Recommendation: Refuse

Applicant: Mr & Mrs Purewal

Proposal: Erection of 4 No dwelling houses with associated garages, access and landscaping

Drawing No.:  
**4176-P-04**

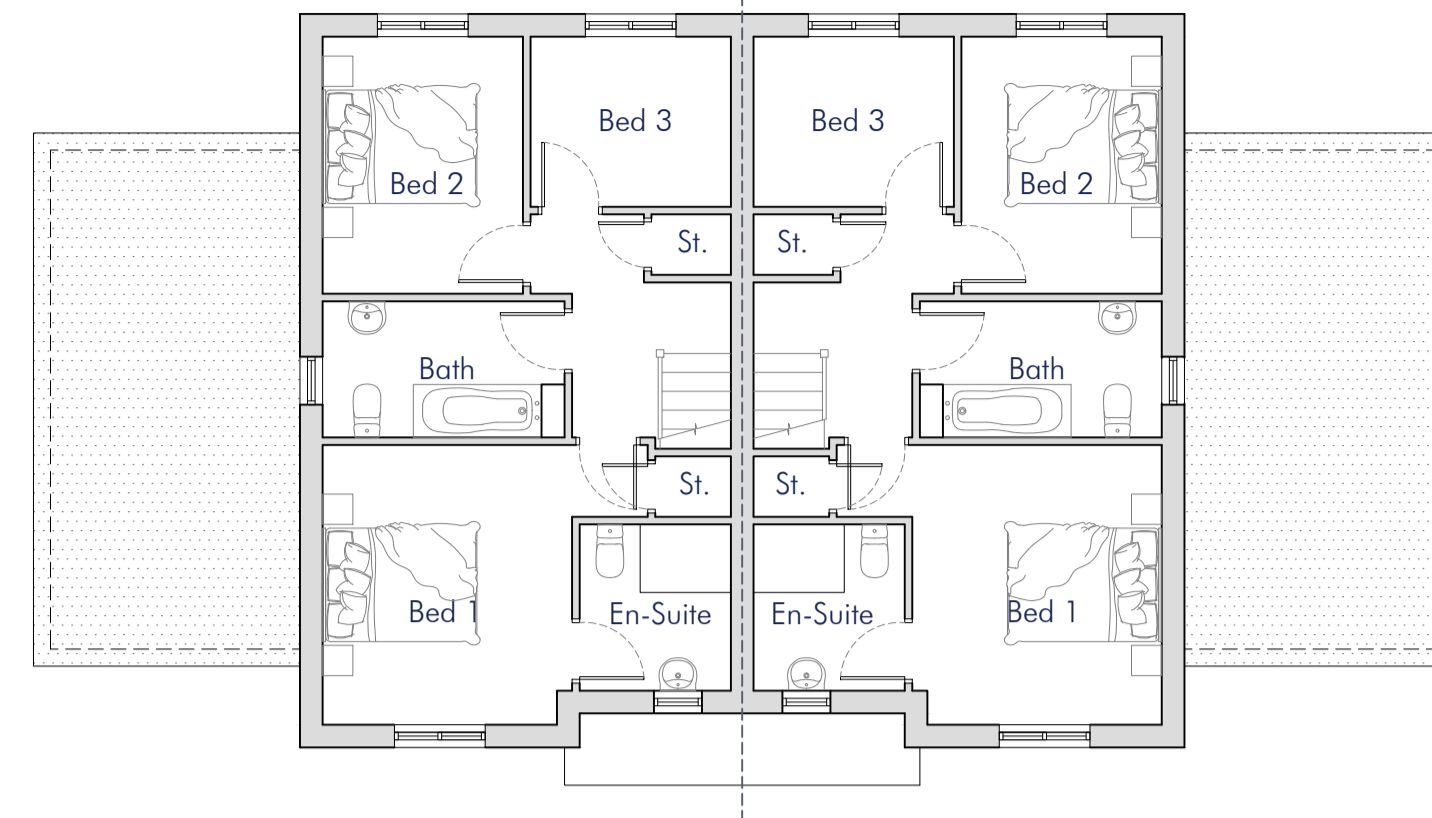
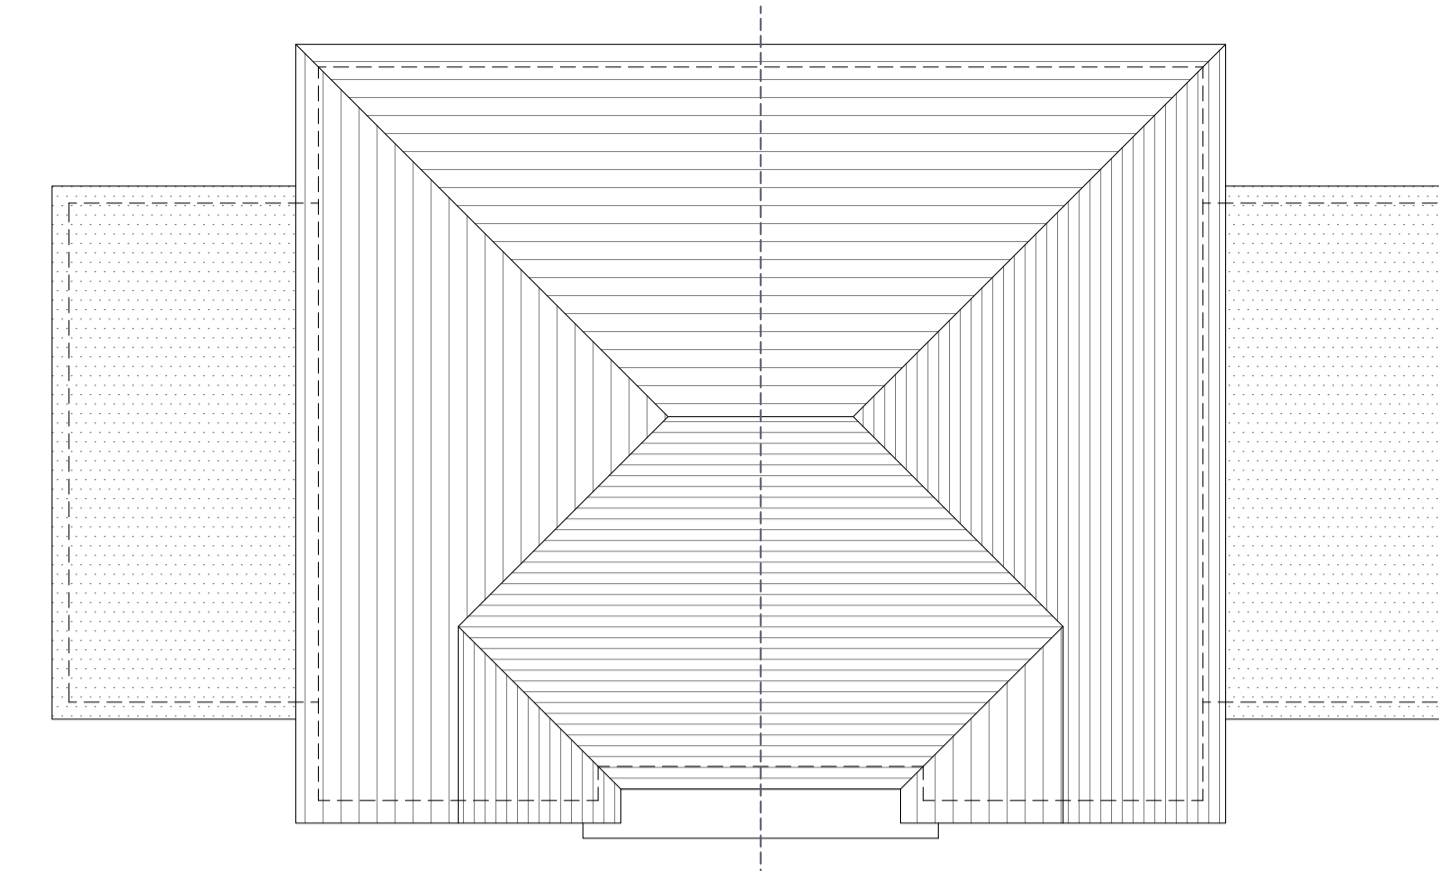
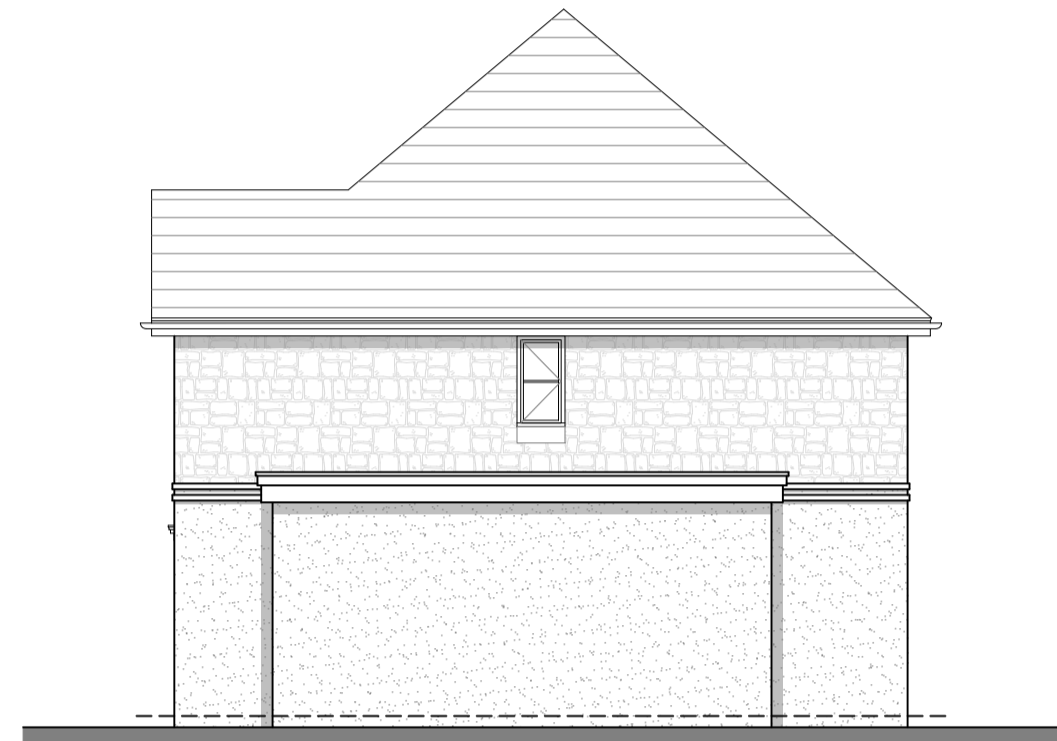
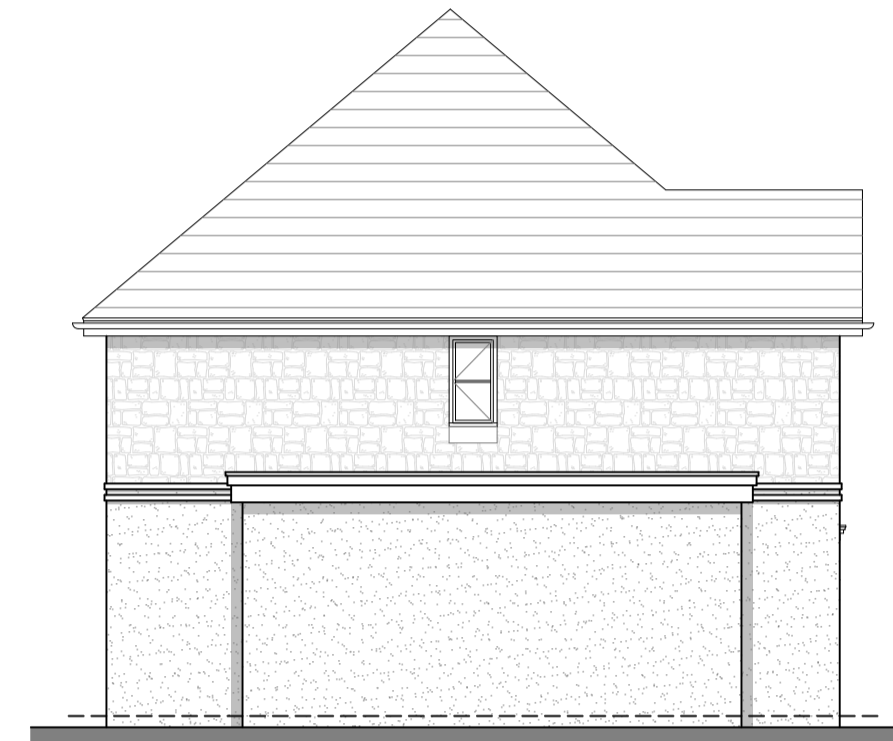
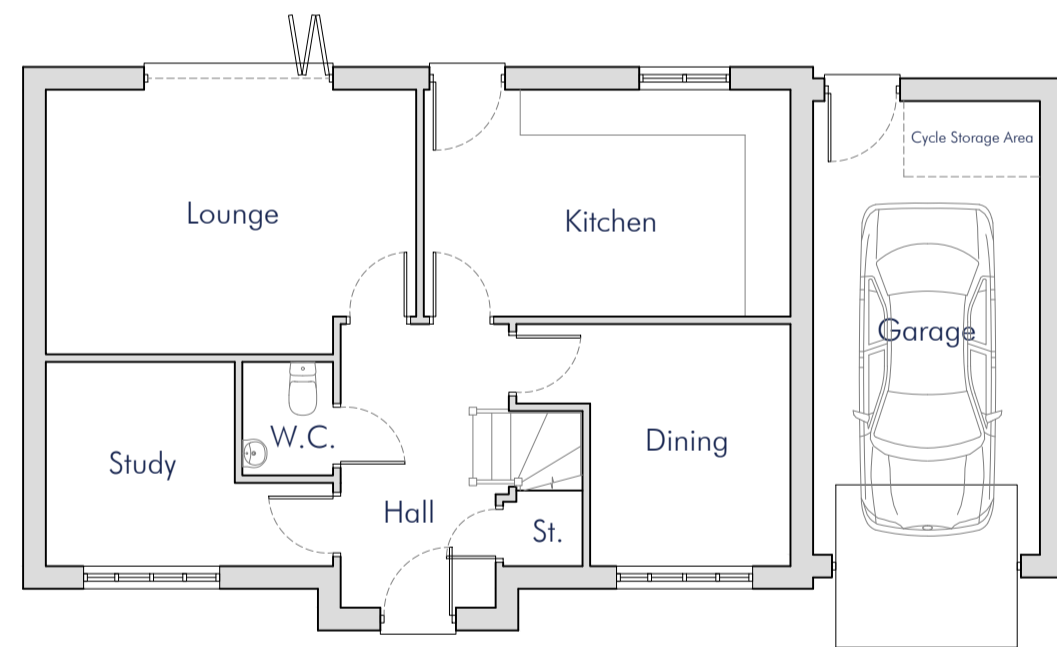
- 8.24. The heights of the semi-detached dwellings at Plots 1-2 is considered particularly harmful to the character and appearance of the wider area, being 9.5m at ridge and thus above the height of the Old Vicarage being over-dominant in the context of the overall streetscene and in public views along Aunt Ems Lane.

- 8.26. The Old Vicarage does feature some rendered elements in later additions to the property, mainly on rear or subservient elements. However, the heavy use of render across this scheme, particularly the whole façade of Plot 3 and the lower 'half-and-half' façade of Plots 1-2, is considered poor design and to not respect the overall character of the wider area and thus is considered to be detrimental to the scheme as a whole.

- 8.27. The garages as submitted are considered to result in poor design in this rural context. In particular, the detached garage to serve Plot 4 is considered overly suburban, failing to respect the existing rural nature of the site and wider area. The flat roof garages to Plots 1-3 are considered a poor detail and, particularly where viewed from Aunt Ems Lane, would detract from the overall appearance of the site.

Drawing No.:
4176-P-05

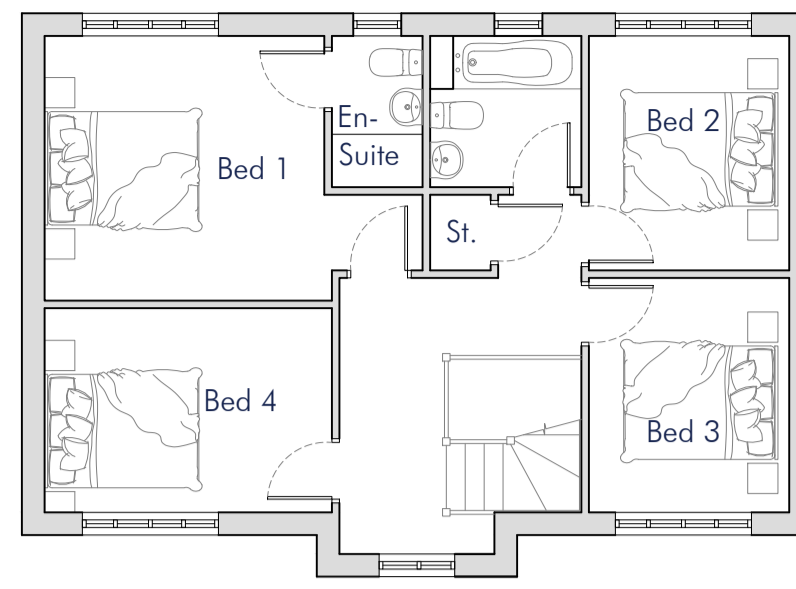
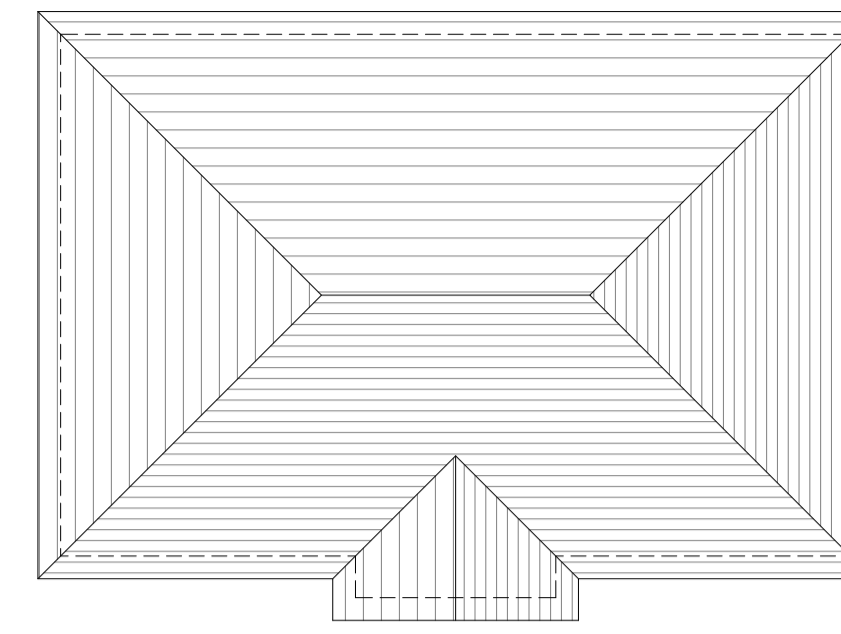
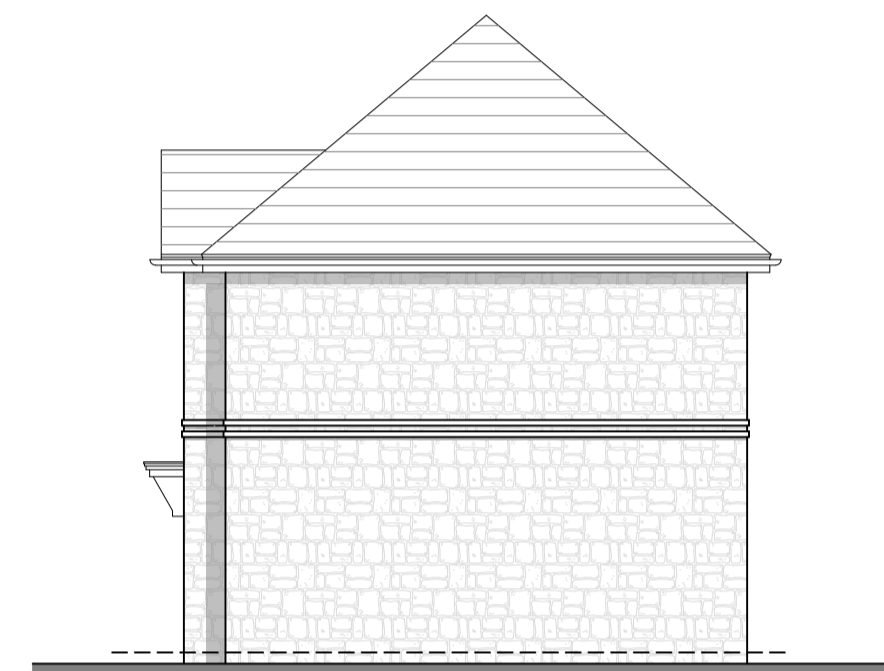
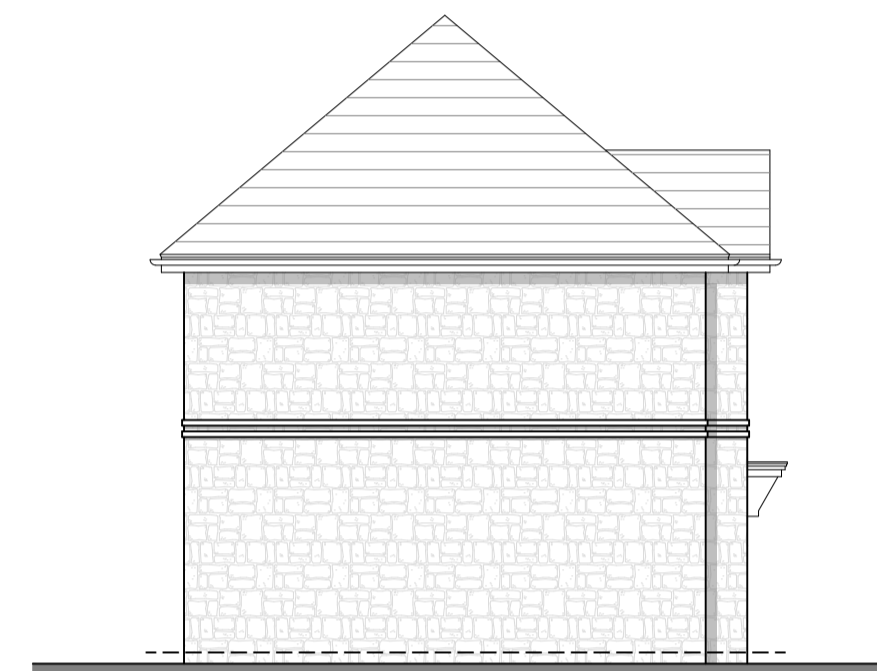
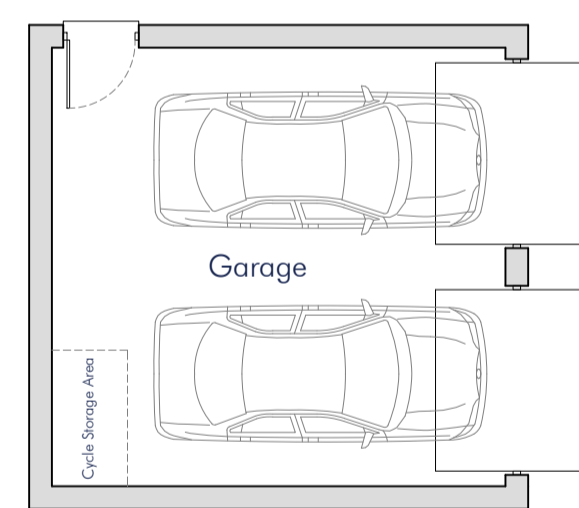
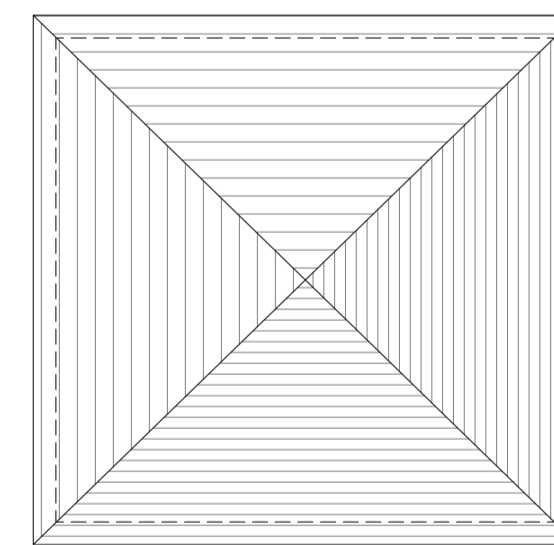
- 8.28. The Council's Arboricultural Officer has raised concerns regard the siting of Plot 4 and its poor relation to the existing vegetation along the northern boundary. The amount of shade offered by this boundary on future occupiers of this plot would create a conflict which could result in the hedgerow being cutback or removed.
